Date: 27 September 2019

Application by Highways England for an Order Granting Development Consent for the A303 Amesbury to Berwick Down

Notification of Procedural Decision in respect of eight proposed changes to the application (NMC-01 to NMC-08) put forward by the Applicant in [[AS-067](#)], as amended in relation to NMC-02, NMC-06 and NMC-07 in [[REP8-015](#)]

Drawing Title: **RIGHTS OF WAY AND ACCESS PLANS REGULATION 5(2)(k) & 5(2)(o) SHEET 14 OF 15**

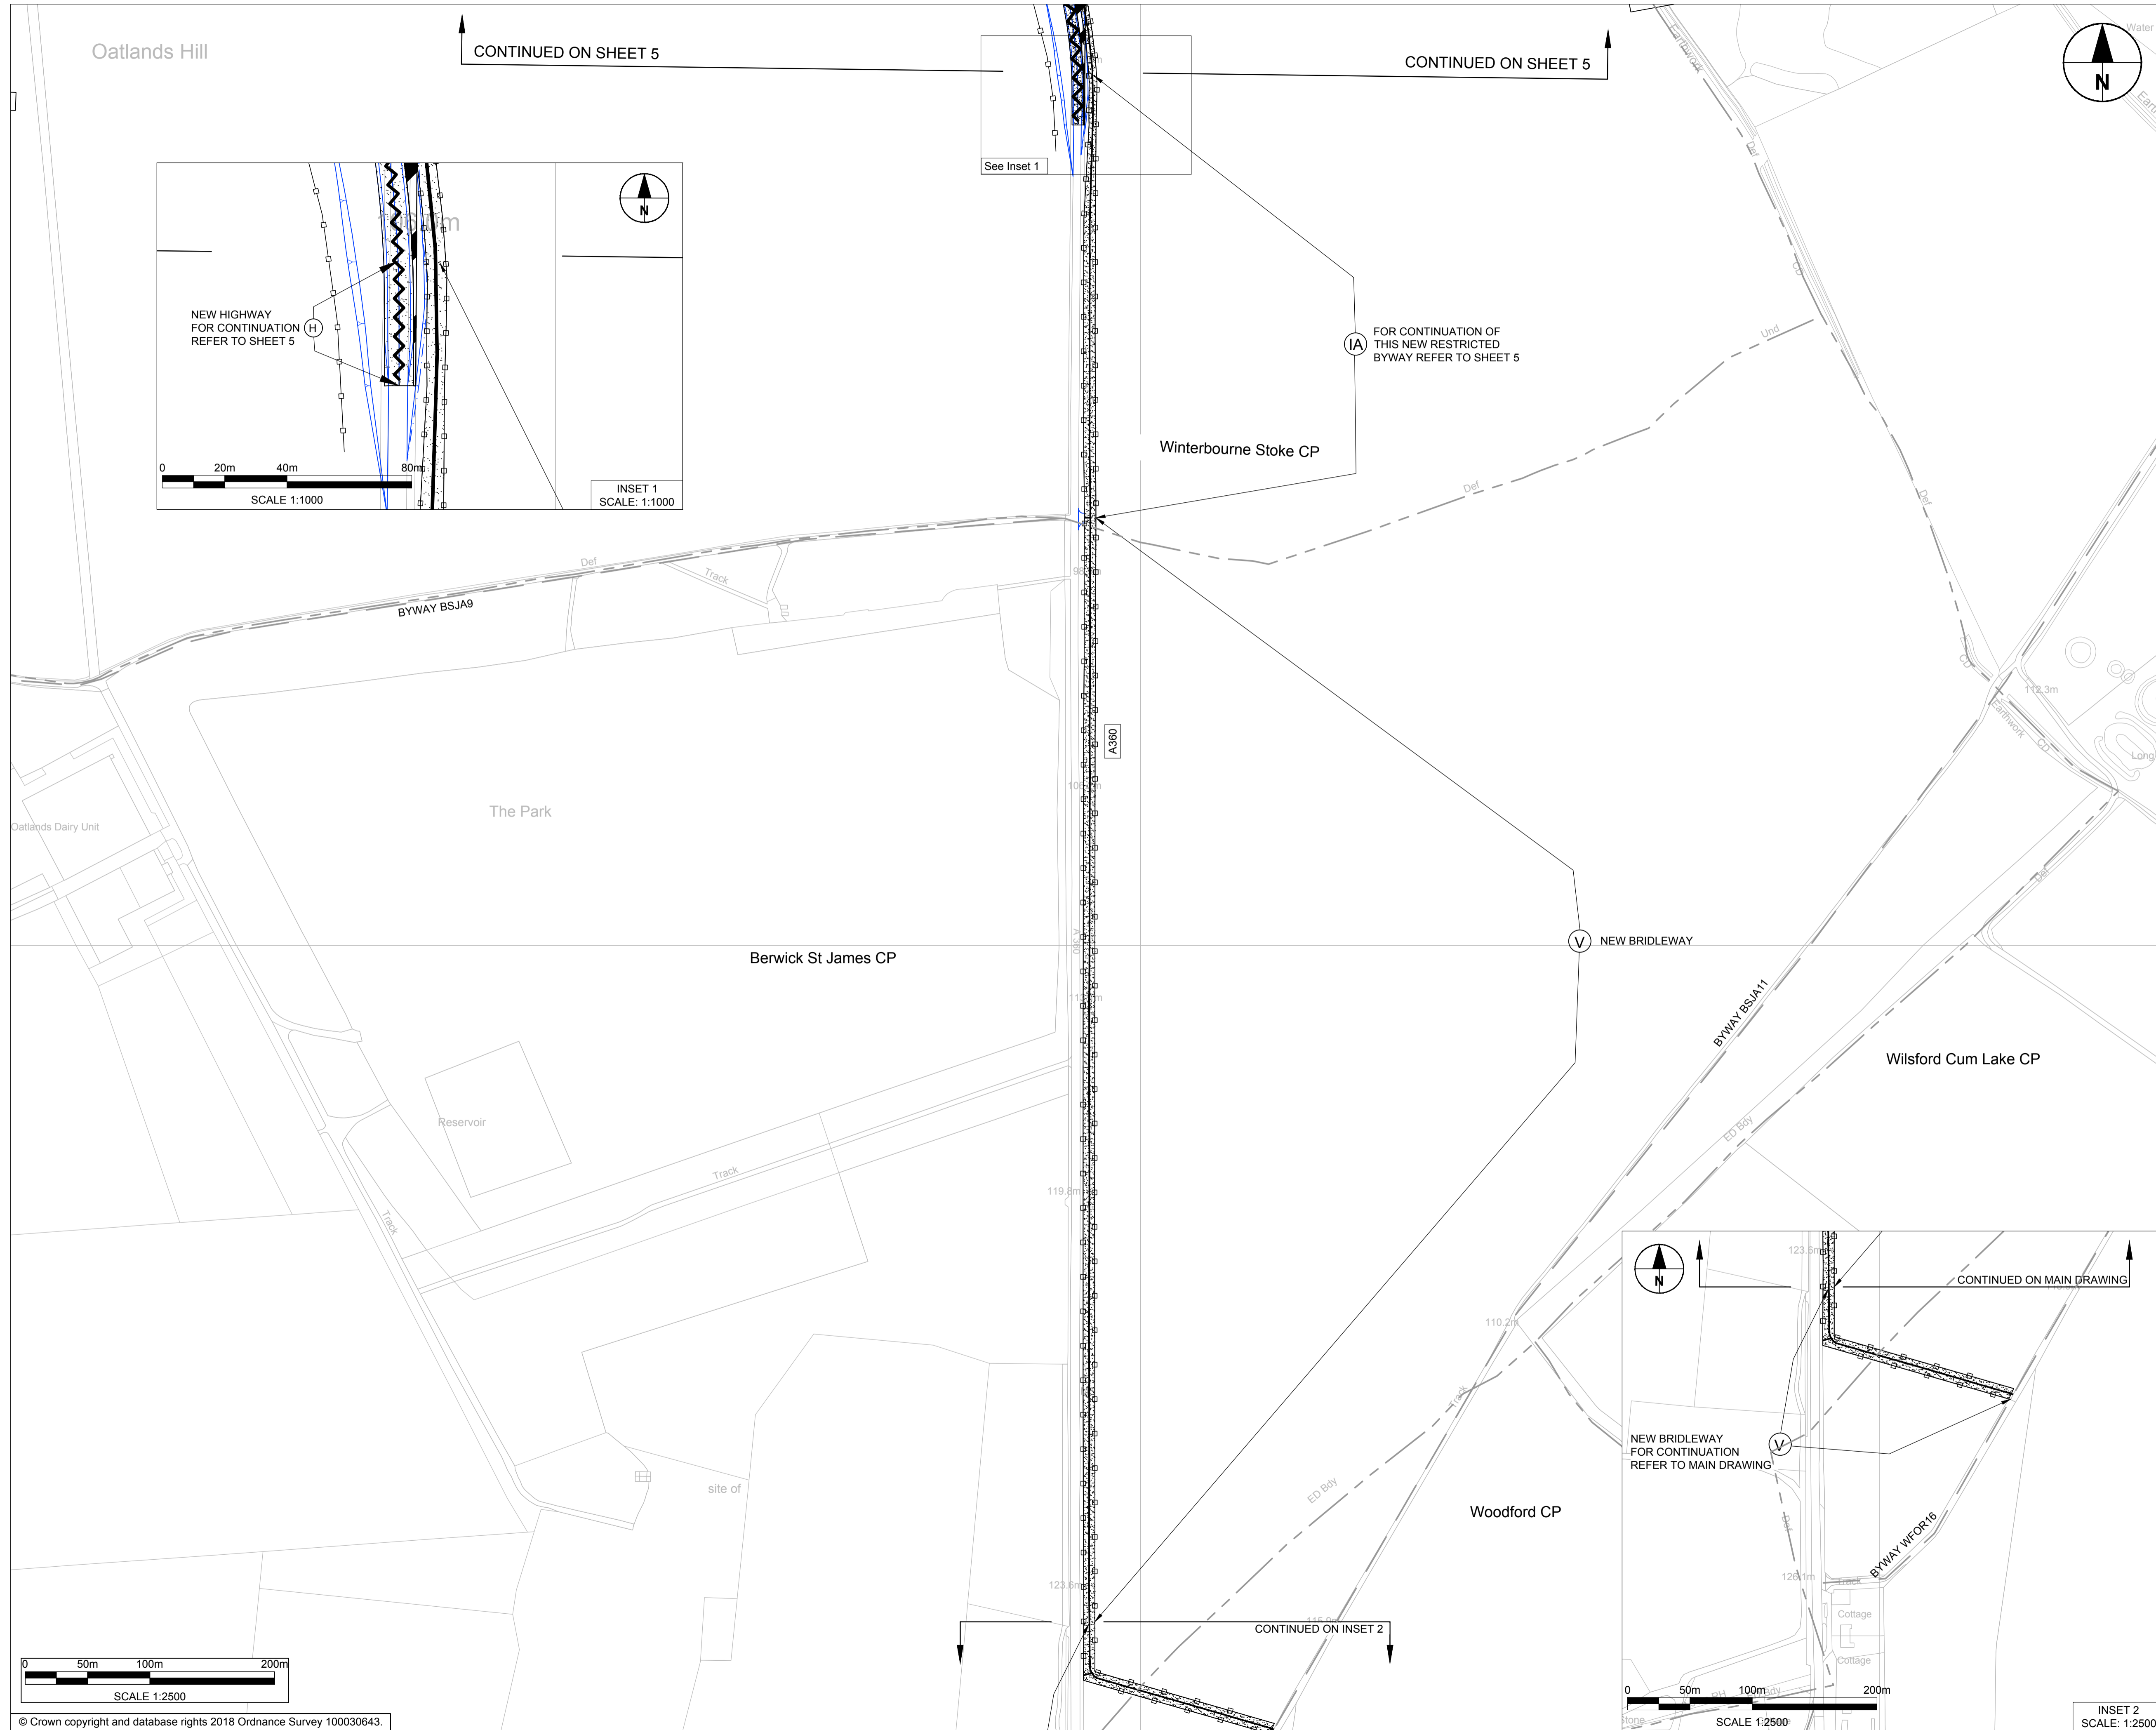
NMC-05 - *Revised proposal for access to land next to the existing A360 north of Longbarrow*

NMC-05 remains as originally proposed in the Proposed Changes Application [[AS-067](#)] and the Proposed Changes Consultation Booklet (Appendix A1 to the Consultation Report). However, a replacement 'after' sketch for NMC-05 (Sheet 14 of the Rights of Way and Access Plans [[APP-009](#)]) has been provided, in which the omission, in the version of the sketch in the Consultation Booklet, of a directional label for 'Insets 1A & 1B', has been rectified.
